**Albuquerque
Metropolitan
Arroyo
Flood
Control
Authority**

Re: Sunrise Ranch Drainage Report (revised), 6/23/00
(L9/D6)

FIGURE 3: SNOW VISTA BASIN MANAGEMENT PLAN

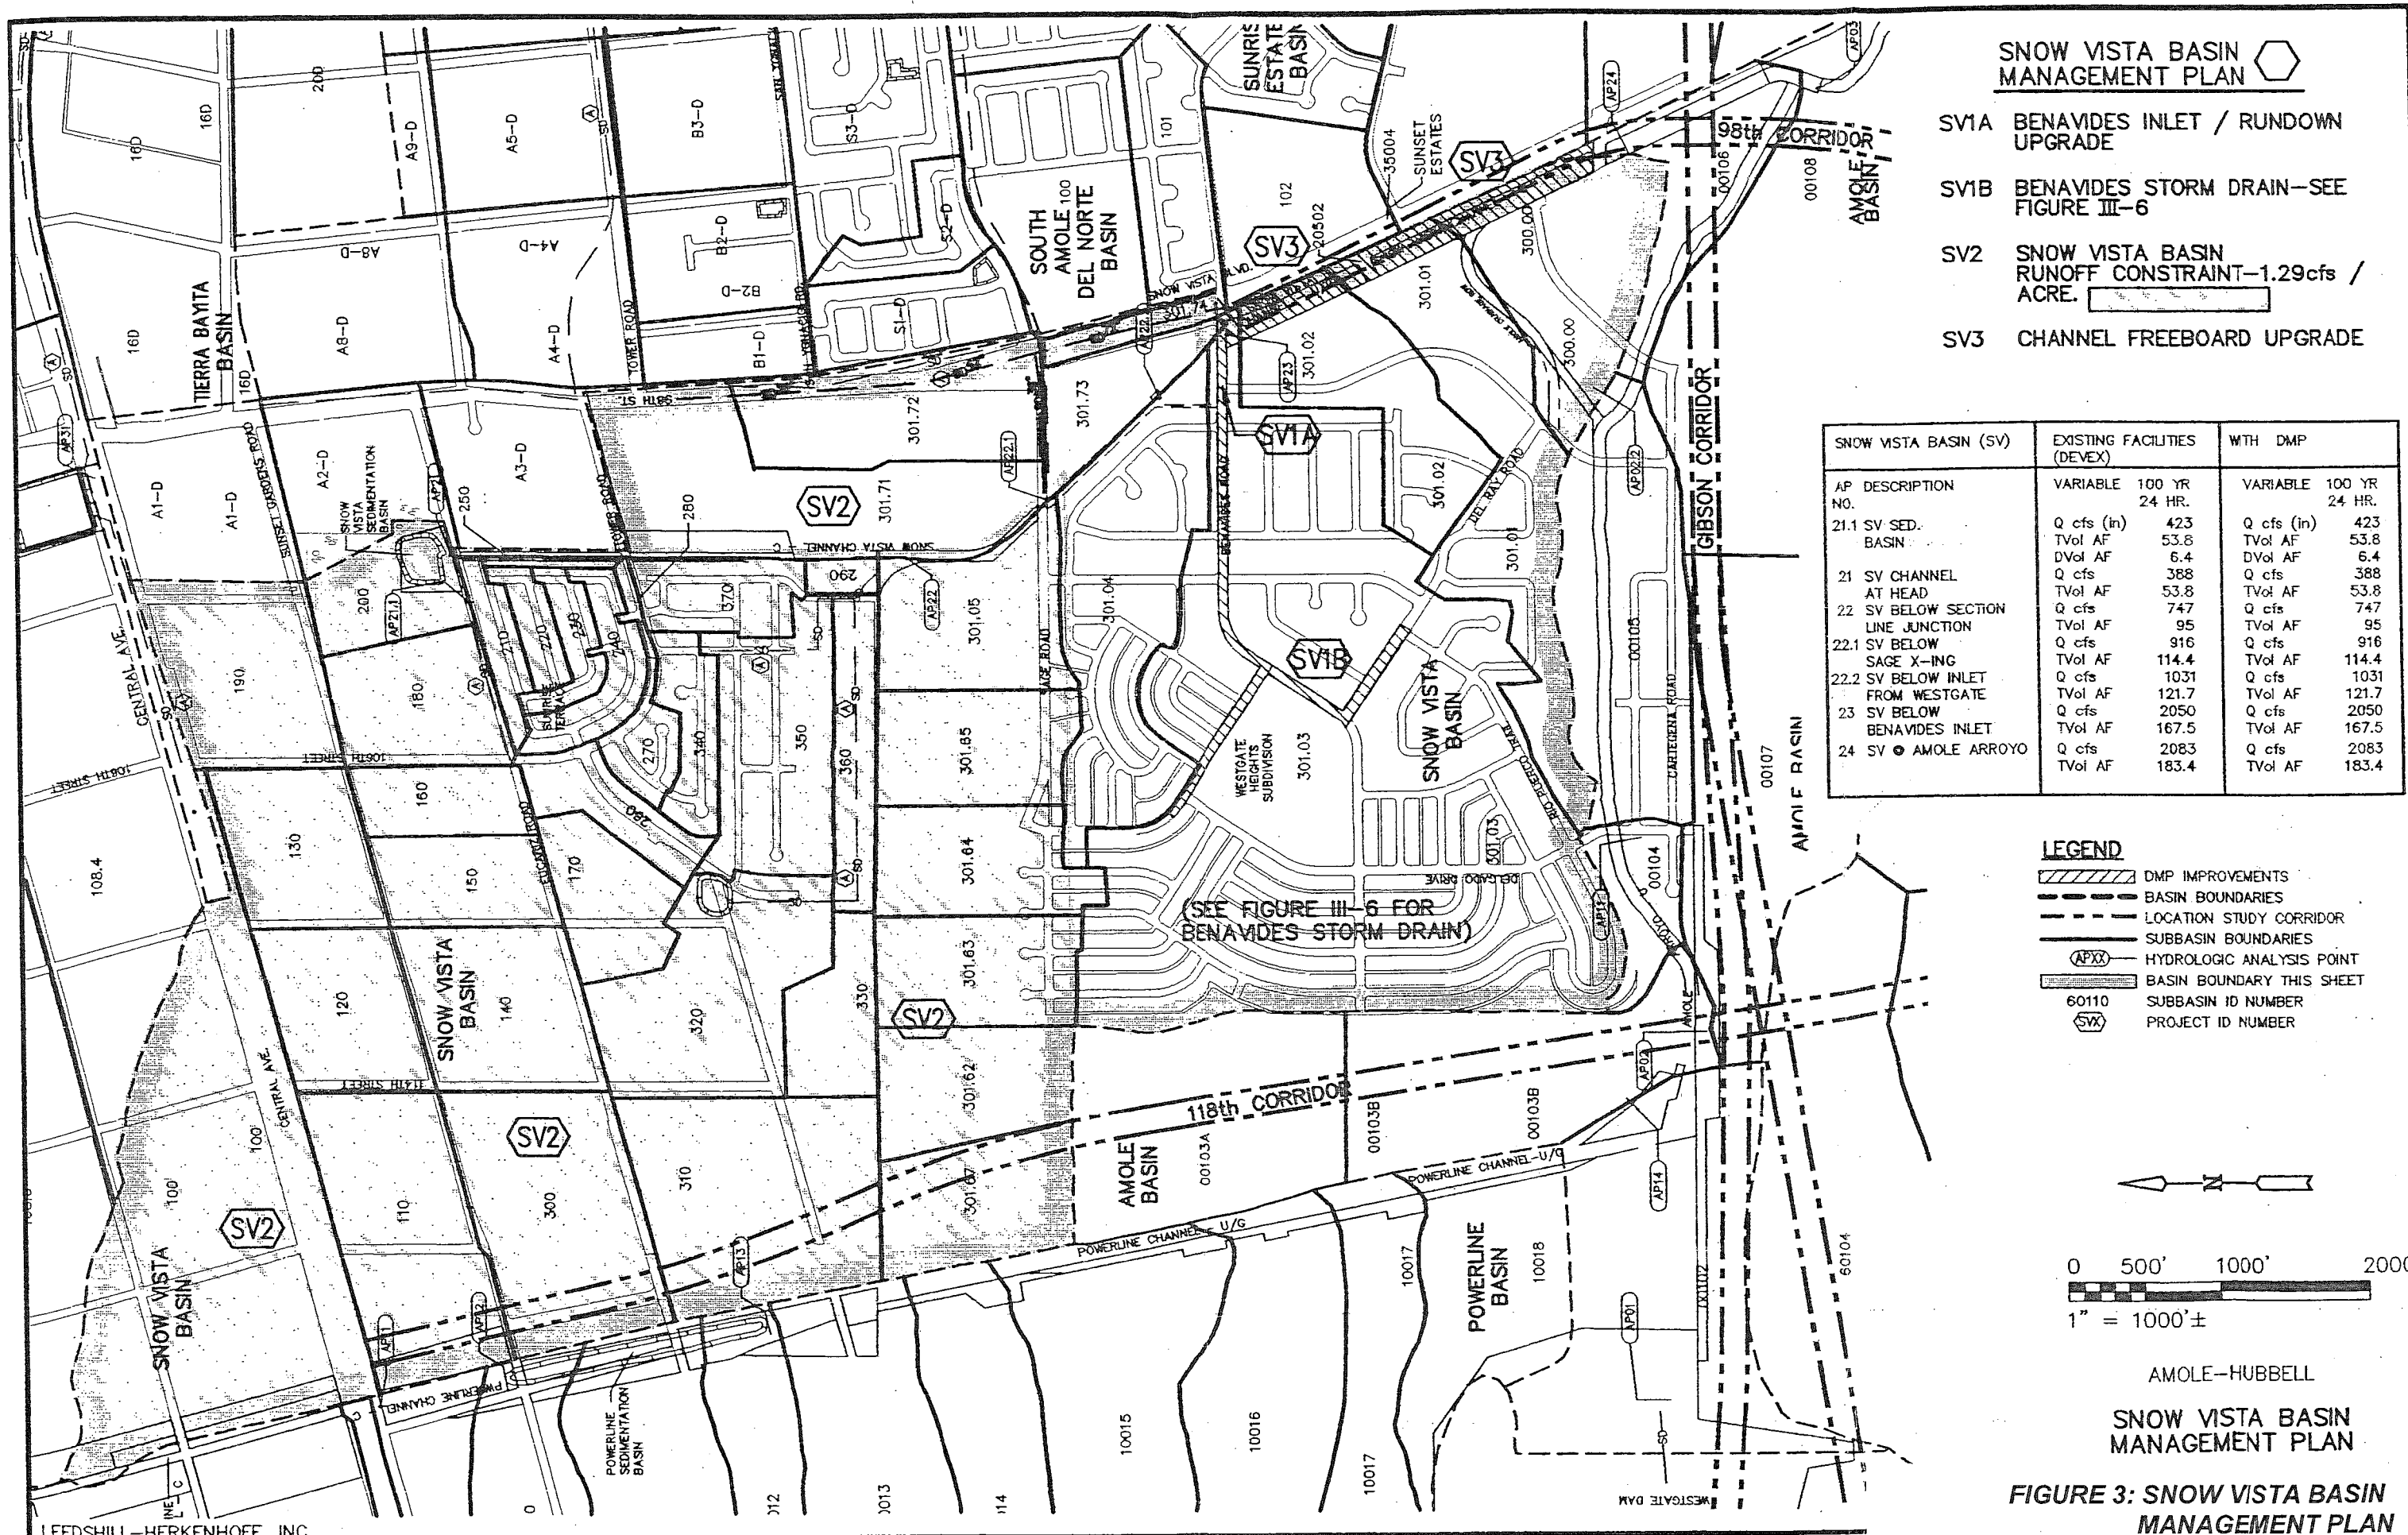
5. Show proposed AMAFCA floodplain easement (to HGL) on figure with contours.
6. Sub-basin 200 is clearly in the 1.29 cfs/acre constraint area shown in Figure I-2 (your figure 3) of the Amole-Hubbell DMP.

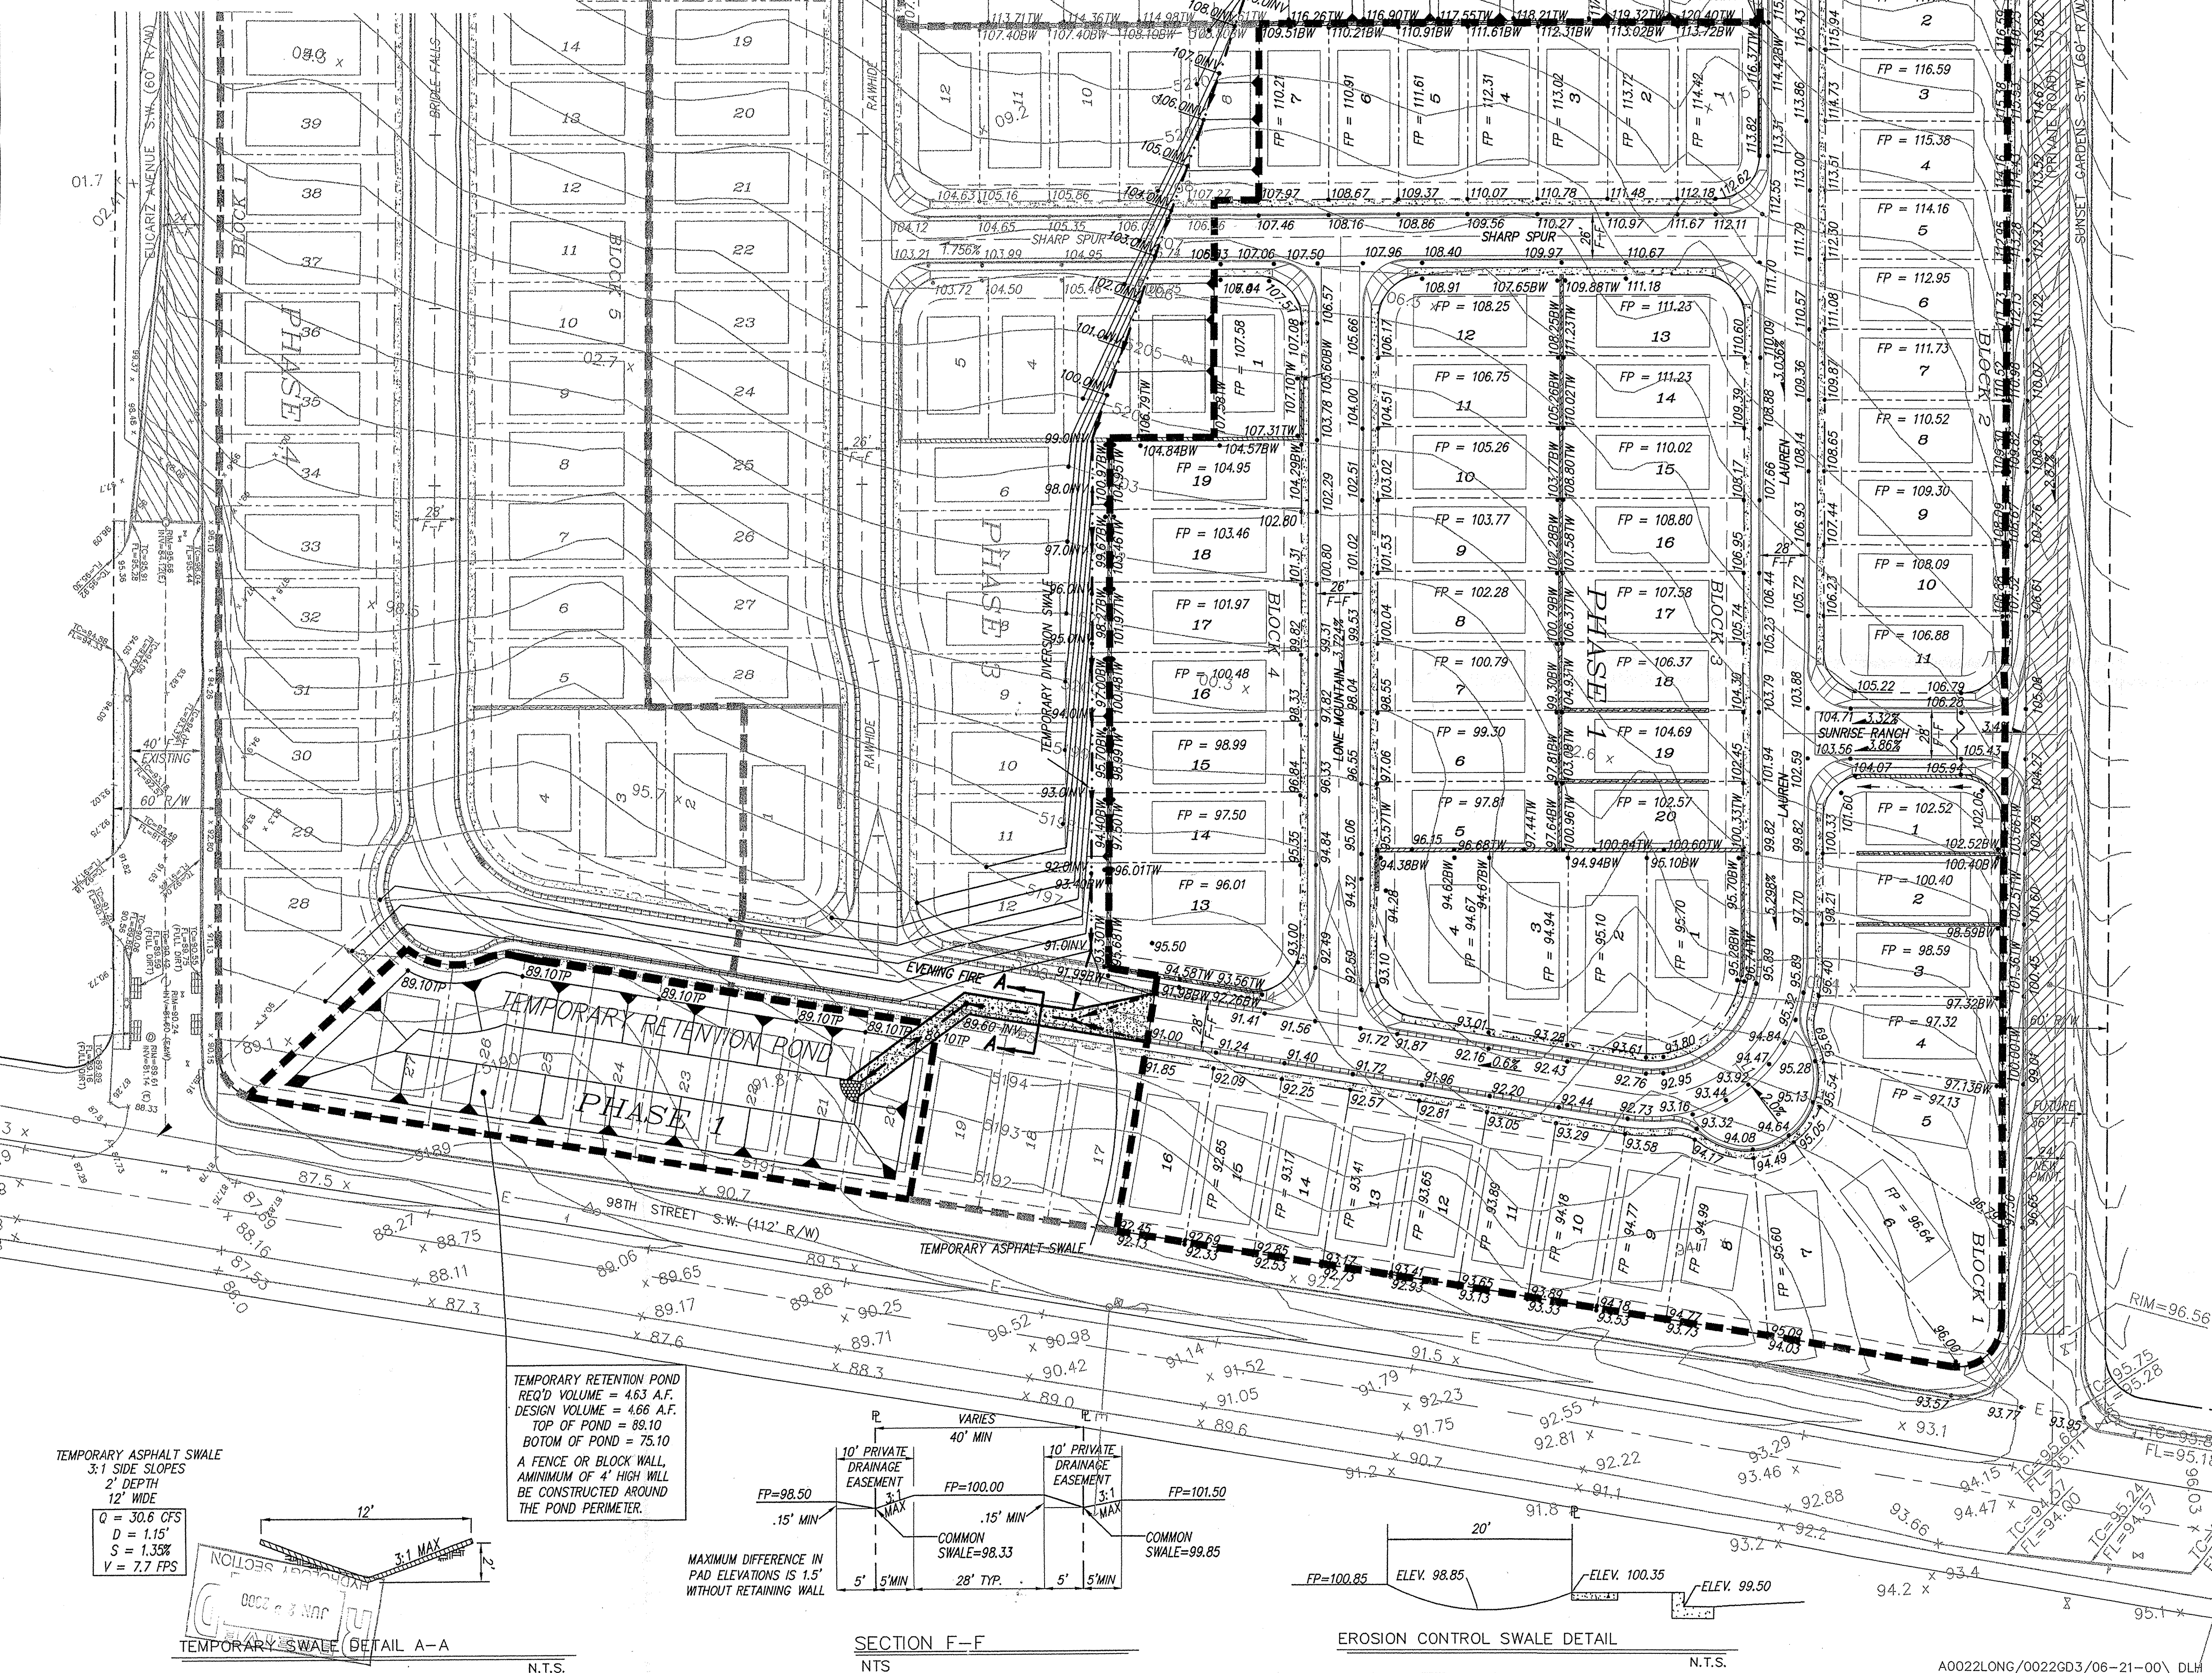
9. It is unclear where the "temporary" asphalt swale is to be located. Is it the same one shown in section on sheet 1 of 2 of the G&D Plan (which shows no asphalt)?
